**KIRKLEES COUNCIL
TOWN AND COUNTRY PLANNING ACT 1990
HIGHWAYS DEVELOPMENT MANAGEMENT**

PLANNING REF 2018/60/92686/E0/GW
CATEGORY Large Major

PROPOSAL OUTLINE APPLICATION FOR
ERECTION OF RETAIL(A1) AND
DRIVE THRU RESTAURANT(A3)
DEVELOPMENT AND ASSOCIATED
CAR PARKING, LANDSCAPING AND
INFRASTRUCTURE

LOCATION LAND ADJ 127 WESTGATE
HECKMONDWIKE
WF16 0EW

Title
Proposed Site Layout

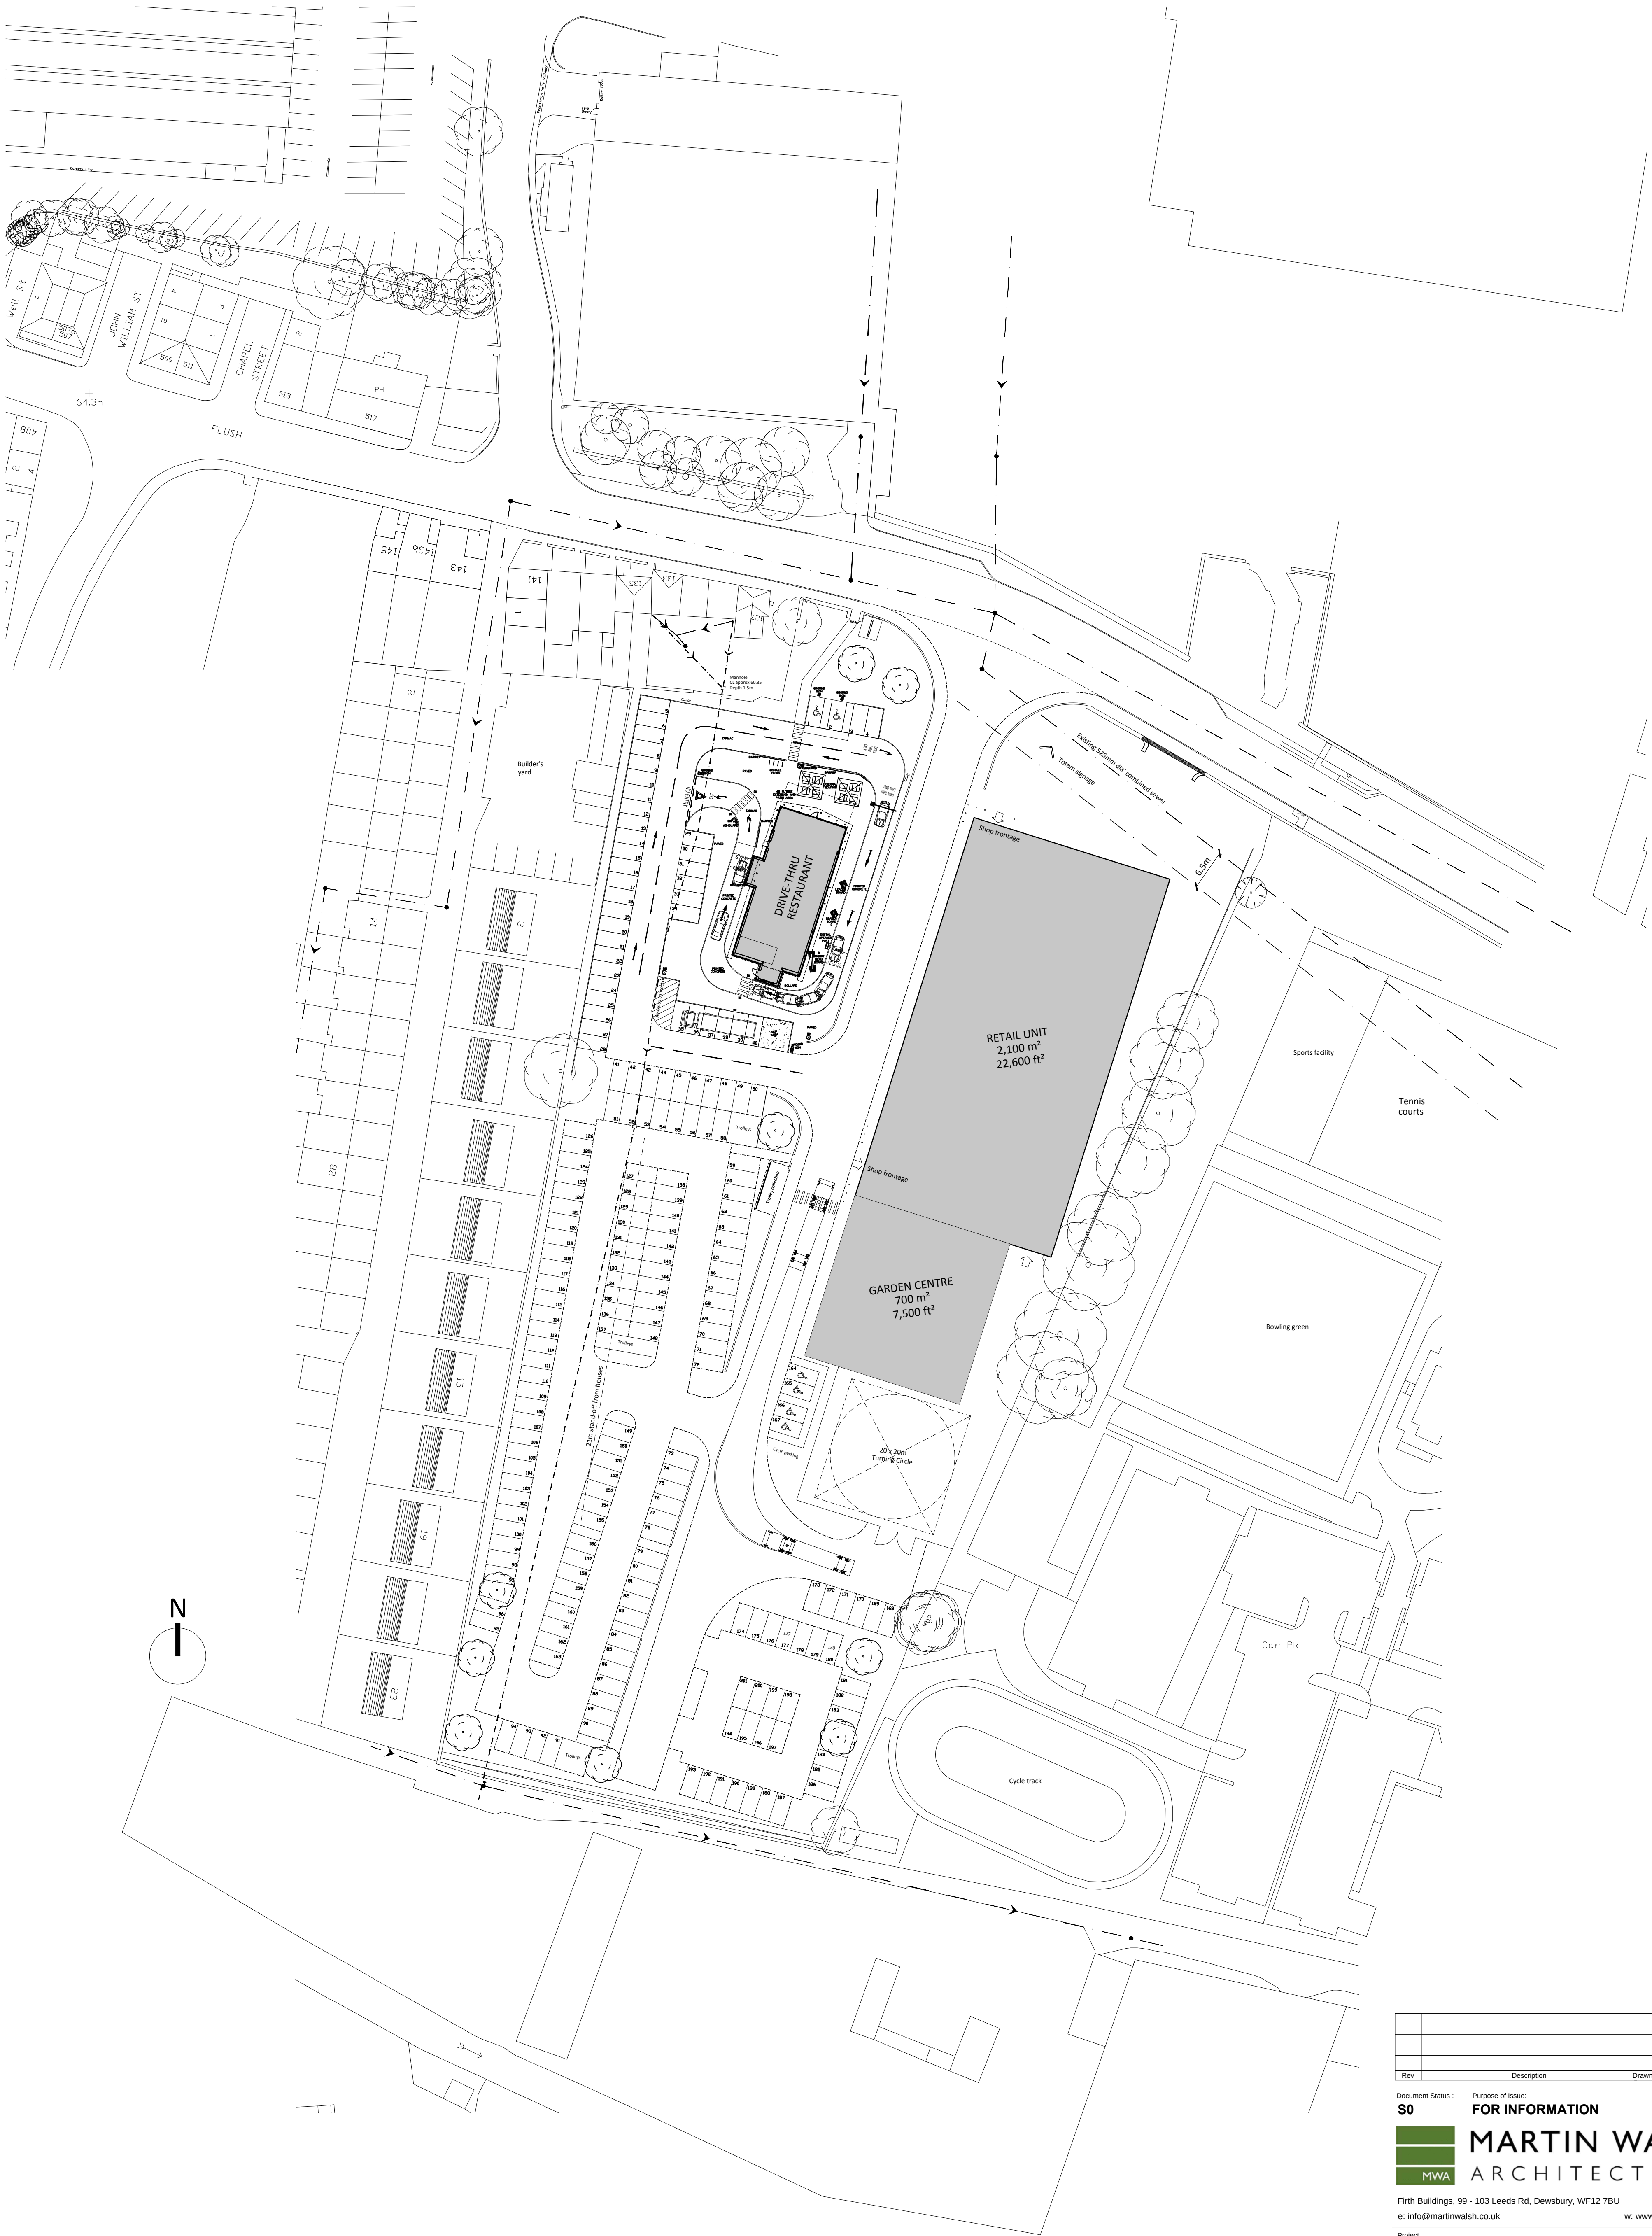
The bus layby shown to be re-positioned on Westgate would require passing traffic to be partially on the opposing lane on a bend.

A bus stationed in the Westgate carriageway will block visibility for vehicles existing the adjacent industrial access.

The bus stop shown on the plan will impact on the safety of large volume of traffic moving at higher speeds then if it was left in its current location against the volume/speed of traffic exiting (right out only) the new access.

Adequate forward SSD may not be achieved.

Please ensure SSD on the junction areas are based on actual speeds.

The proposed tactile paving shown on the new bell mouth is not shown to be laid correctly.

The A638 is narrow to have a bus stop at the location proposed, Highway safety would prefer it where it is unless there is a good reason why it should to be moved. The new proposed location may also impact on visibility to the left when exiting the yard opposite Boundary Street.

Consideration should be given to pulling the kerb line back into the site or re-aligning the Westgate kerb lines/white lining to enable the provision of a new central island on Westgate.

The first car park, which is close to the junction will have a high demand. If it is to remain, sight lines and forward visibility needs to be checked and the access should be a 'dropped crossing' and not have radii?

Where is the secure and sheltered motorcycle parking? This should be located where there is natural surveillance.

The cycle parking should be sheltered and located where there is natural surveillance.

Forward visibility around the bell mouth radii should be checked.

Are 85thile wet weather speeds commensurate with the 43m 'Y' distance?

Is there 5% disabled parking provision on site?

Are electric charging bays to be provided

On balance it is considered that the existing layby should remain in its existing location

The proposed visibility splays onto Westgate should be based on actual speeds

Consideration should be given to the possibility of pulling the kerb line back into the site or re-aligning the Westgate kerb lines/white lining to enable the provision of a central island on Westgate.

The first car park, which is close to the junction with Westgate will have a high demand. If it is to remain, sight lines and forward visibility needs to be checked and the access should be a 'dropped crossing' and not have radii? In order to reduce the demand or use of this car park consideration could be given to re-siting/providing secure and sheltered motorcycle and cycle parking and the 5% disabled parking provision at this location.

Forward visibility around the bell mouth radii should be checked and confirmed.

The electric charging bays to be provided should be shown on the plans.
